EAST PARK ENERGY

Schedule of Changes to the Draft Development Consent Order

Document Reference: EN010141/DR/8.2

Version P06

Rev
P02

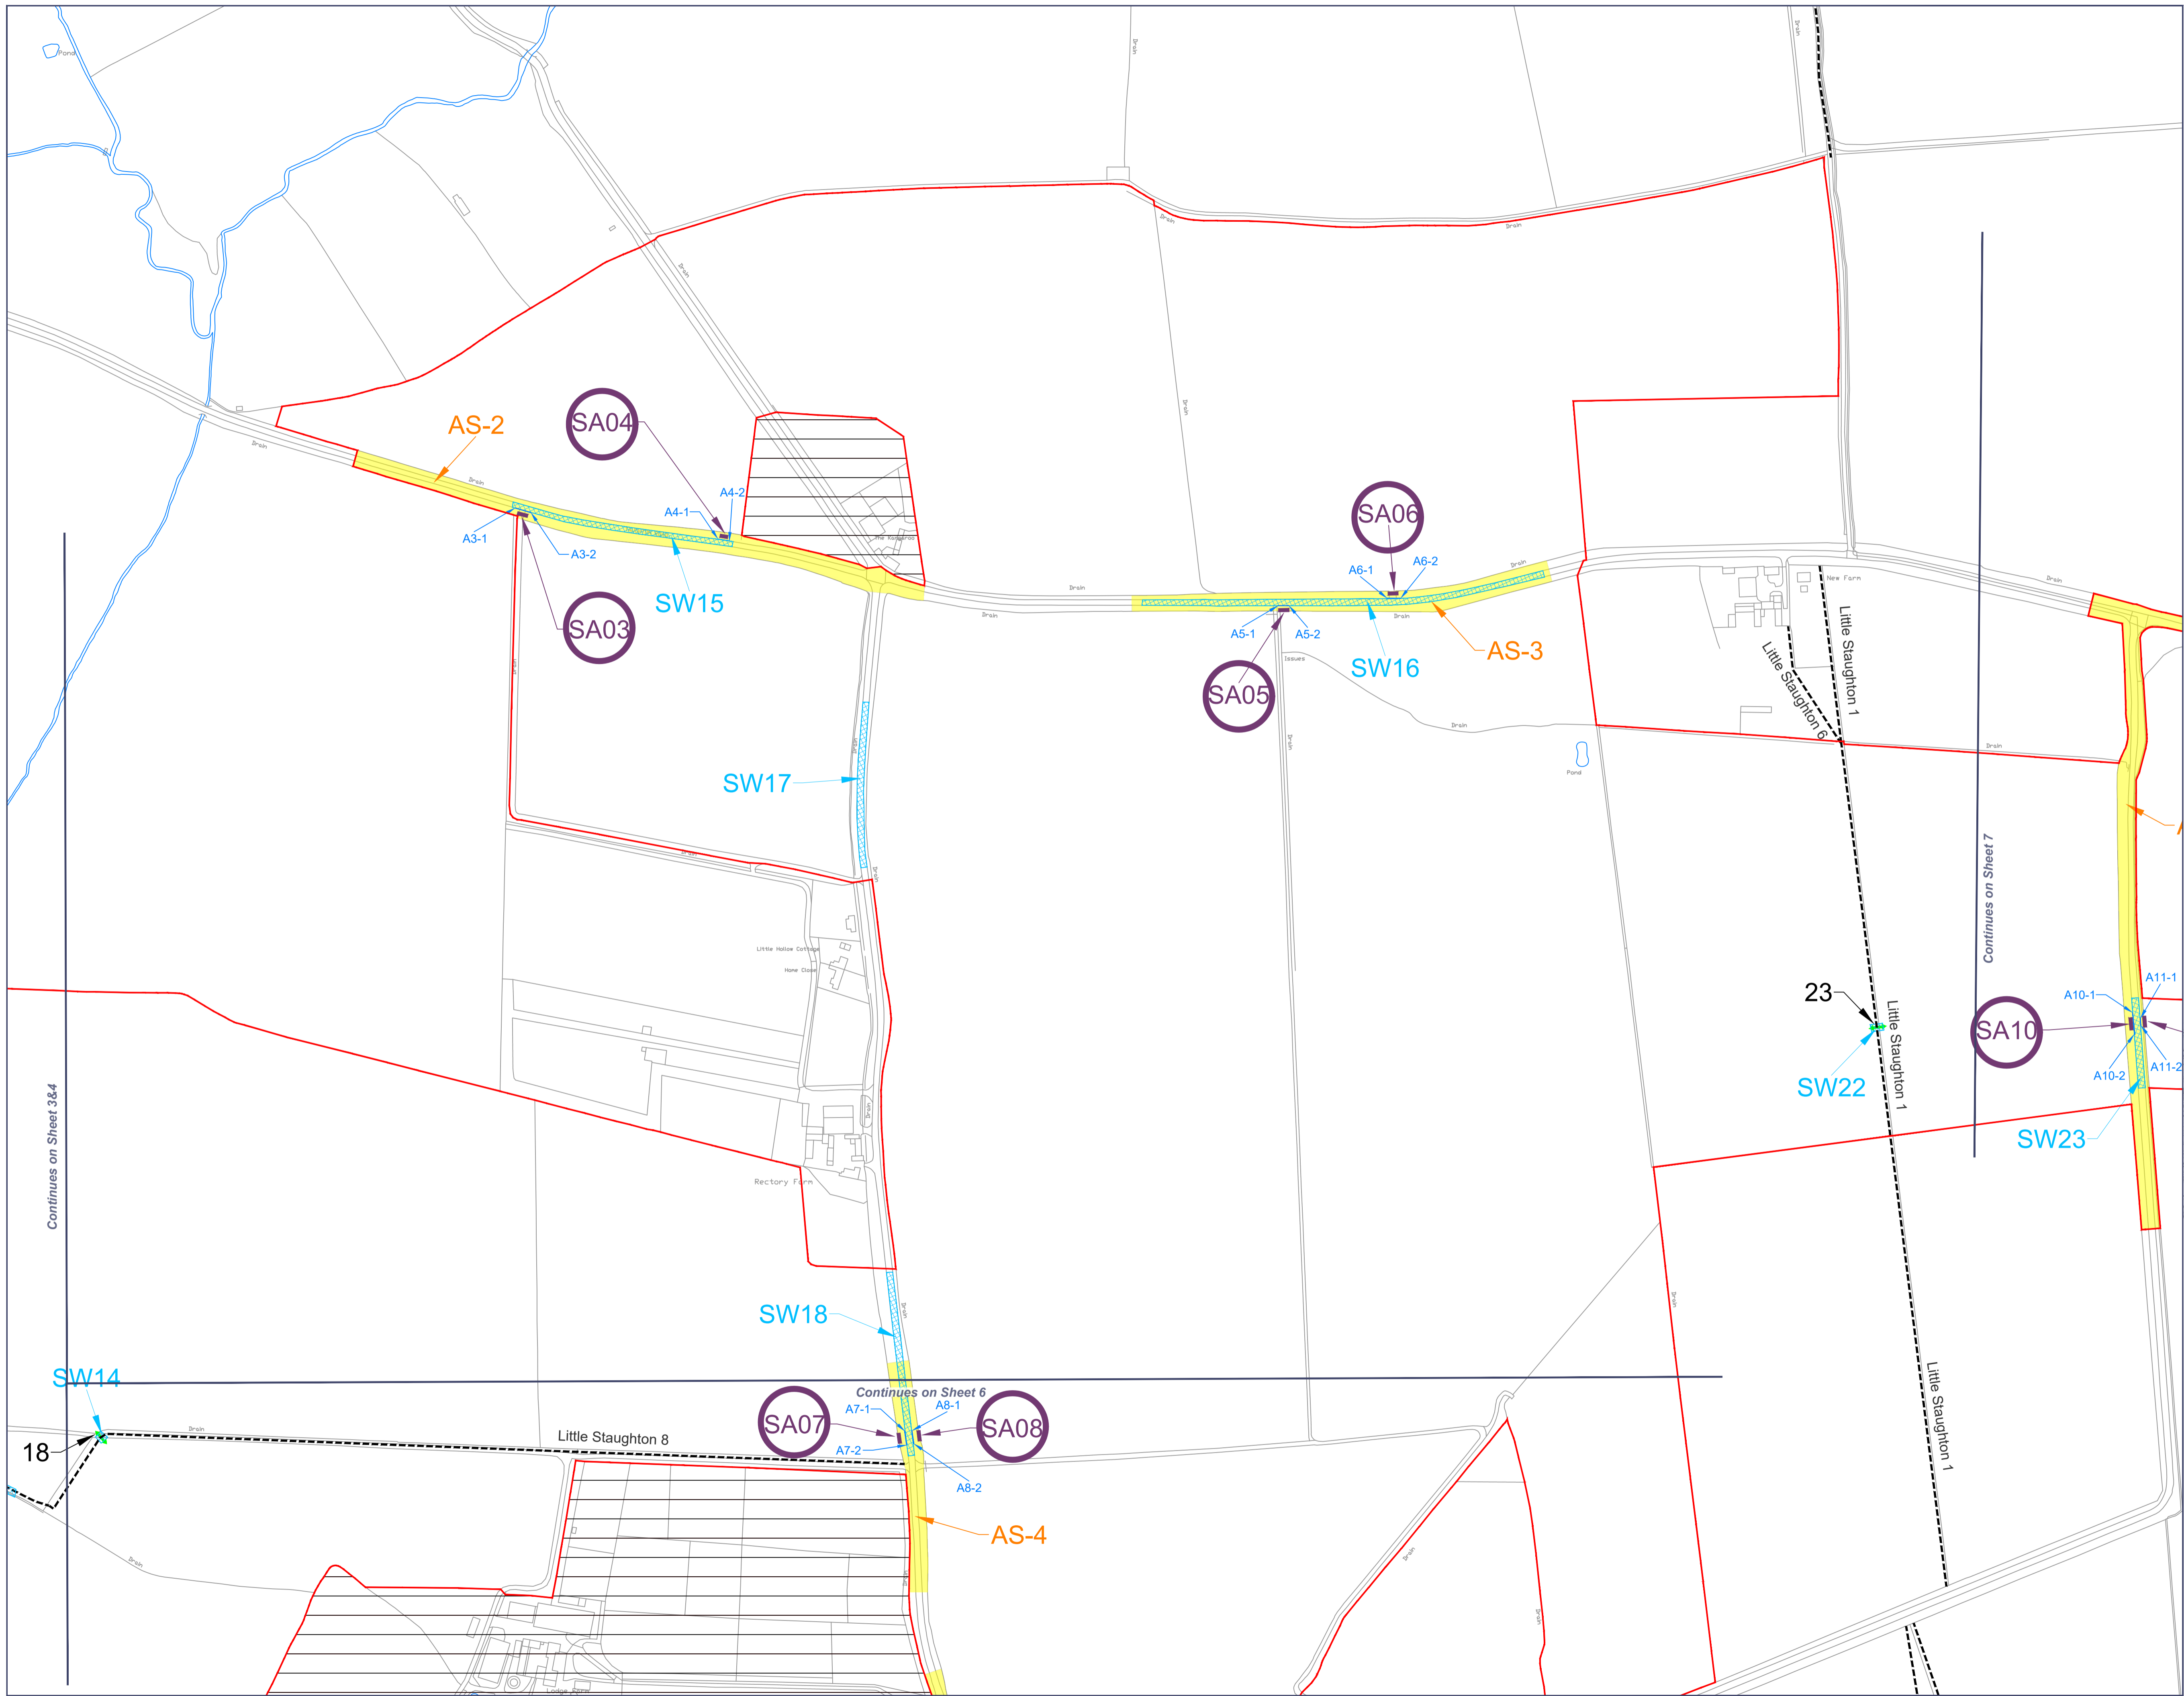
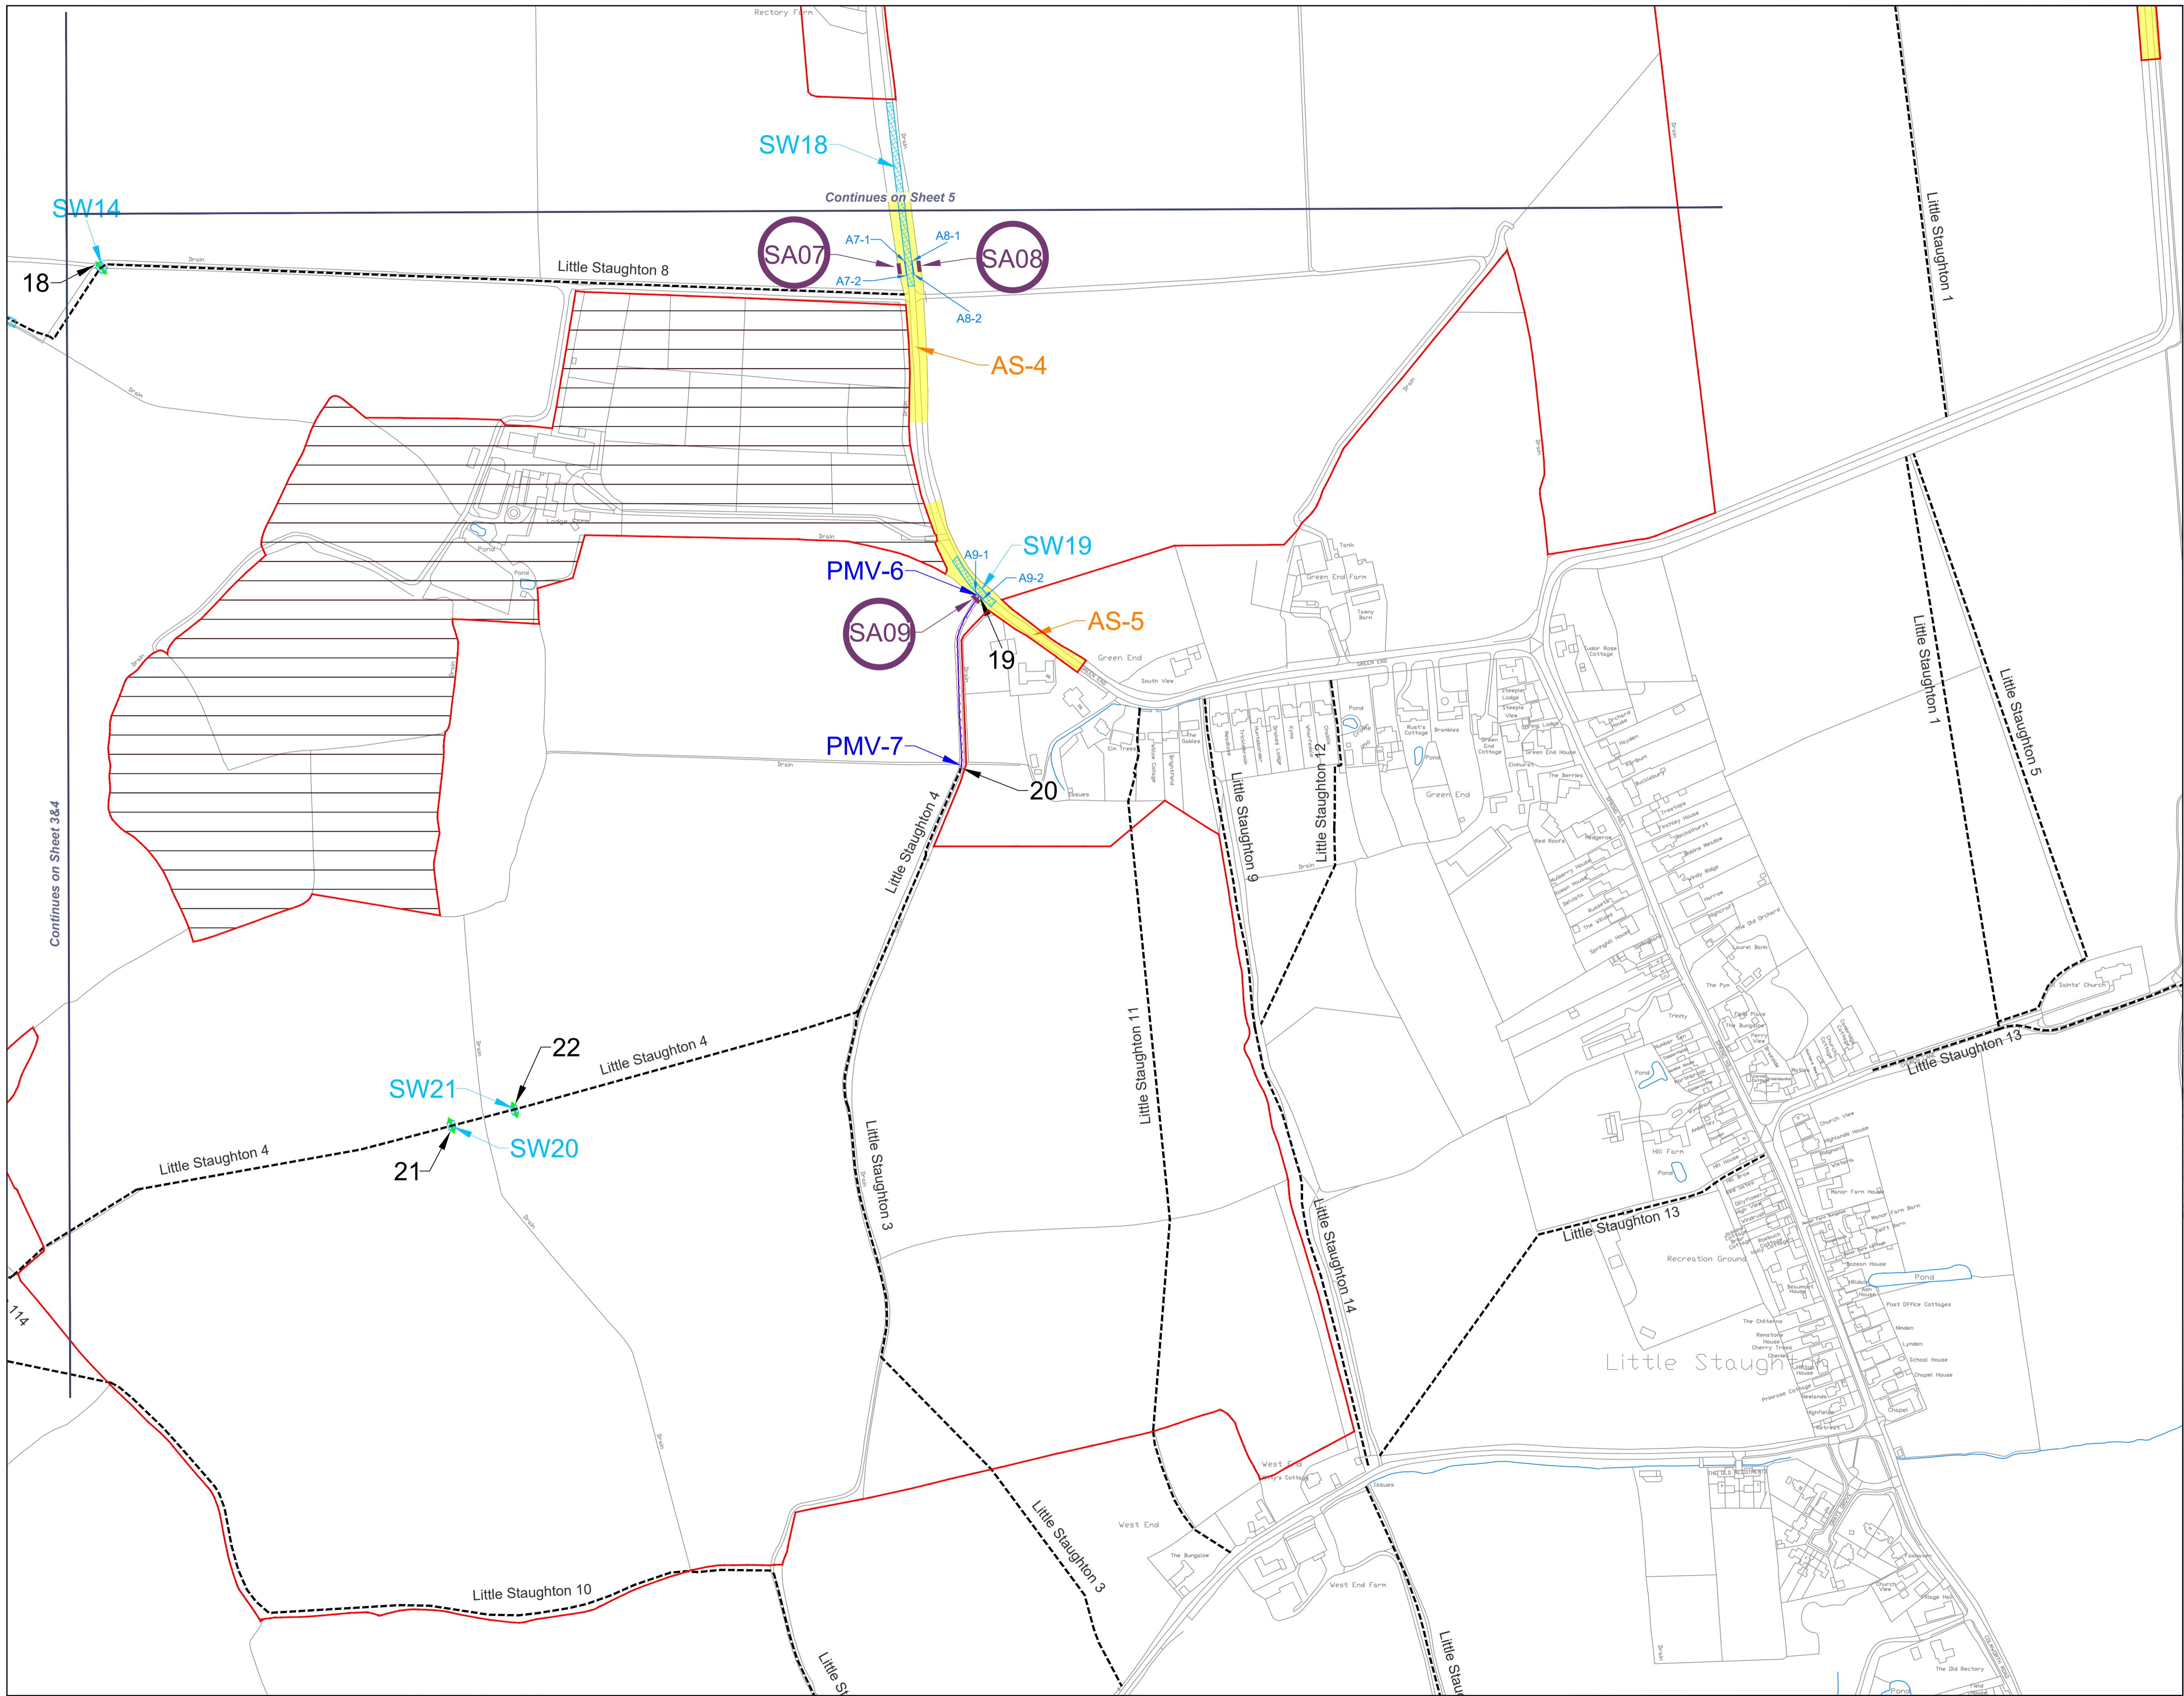
Article / Paragraph / Schedule	Amendment	Reason			
		traffic management plan in accordance with National Highways' relevant representation [RR-904] .			
Schedule 4, Streets subject to street works	A new column (4) has been added listing the relevant highway authority / authorities in relation to each of the streets referenced in the Schedule.	This amendment has been made at the request of Cambridgeshire County Council in their relevant representation [RR-150] .			
Schedule 6, Part 1, Temporary alteration, prohibition, diversion or restriction of the use of streets and public rights of way	Column (2) of the table has been amended as follows: <table border="1"> <tr> <td><i>Pertenhall</i></td><td><i>Public Right of Way – Pertenhall 29 Bridleway Footpath</i></td><td><i>Temporary management including temporary stopping up over the public right of way comprising a length of 455m between the point marked 1 on sheet 1, and the point marked 2 on sheets 1 and 3 of the streets, public rights of way and access plans.</i></td></tr> </table> "Public Right of Way – Pertenhall 29 Bridleway Footpath"	<i>Pertenhall</i>	<i>Public Right of Way – Pertenhall 29 Bridleway Footpath</i>	<i>Temporary management including temporary stopping up over the public right of way comprising a length of 455m between the point marked 1 on sheet 1, and the point marked 2 on sheets 1 and 3 of the streets, public rights of way and access plans.</i>	Correction of typographic error.

<i>Pertenhall</i>	<i>Public Right of Way – Pertenhall 29 Bridleway Footpath</i>	<i>Temporary management including temporary stopping up over the public right of way comprising a length of 455m between the point marked 1 on sheet 1, and the point marked 2 on sheets 1 and 3 of the streets, public rights of way and access plans.</i>			
Schedule 6, Part 2, Authorising permanent use of	A new row has been added to the table as follows: <table border="1"> <tr> <td><i>Pertenhall</i></td><td><i>Public Right of Way – Pertenhall 2 Footpath</i></td><td><i>Motor vehicles authorised by the undertaker may pass along or cross the length of the public right of</i></td></tr> </table>	<i>Pertenhall</i>	<i>Public Right of Way – Pertenhall 2 Footpath</i>	<i>Motor vehicles authorised by the undertaker may pass along or cross the length of the public right of</i>	This public right of way was incorrectly omitted from the draft

Article / Paragraph / Schedule	Amendment			Reason
motor vehicles on public rights of way			<i>way between the point marked PMV-1 on sheet 1 and the point marked PMV-2 on sheets 1 and 3 of the streets, public rights of way and access plans shown shaded blue.</i>	Development Consent Order.
Schedule 8, Part 2, Temporary Suspension of Weight Restriction	Part 2 of Schedule 8 has been deleted in its entirety. This means that what was Part 3 of Schedule 2 is now Part 2.			This Schedule has been removed as the temporary suspension of the weight restriction is no longer required. Please see comments above in relation to Article 17 (traffic regulation measures).
Schedule 13, Part 3, Paragraph 18, For the protection of the drainage authorities	The definition of “specified works” at paragraph 18 has been updated as follows: ““specified work” means so much of any work or operation authorised by this Order as is in, on, under, over or within the watercourse 16 metres of a drainage work or is otherwise likely to— (a) affect any drainage work or the volumetric rate of flow of water in or flowing to or from any drainage work; (b) affect the flow, purity, or quality of water in any watercourse; or (c) affect the conservation, distribution or use of water resources.”			This amendment has been made at the request of Cambridgeshire County Council in their relevant representation [RR-150].
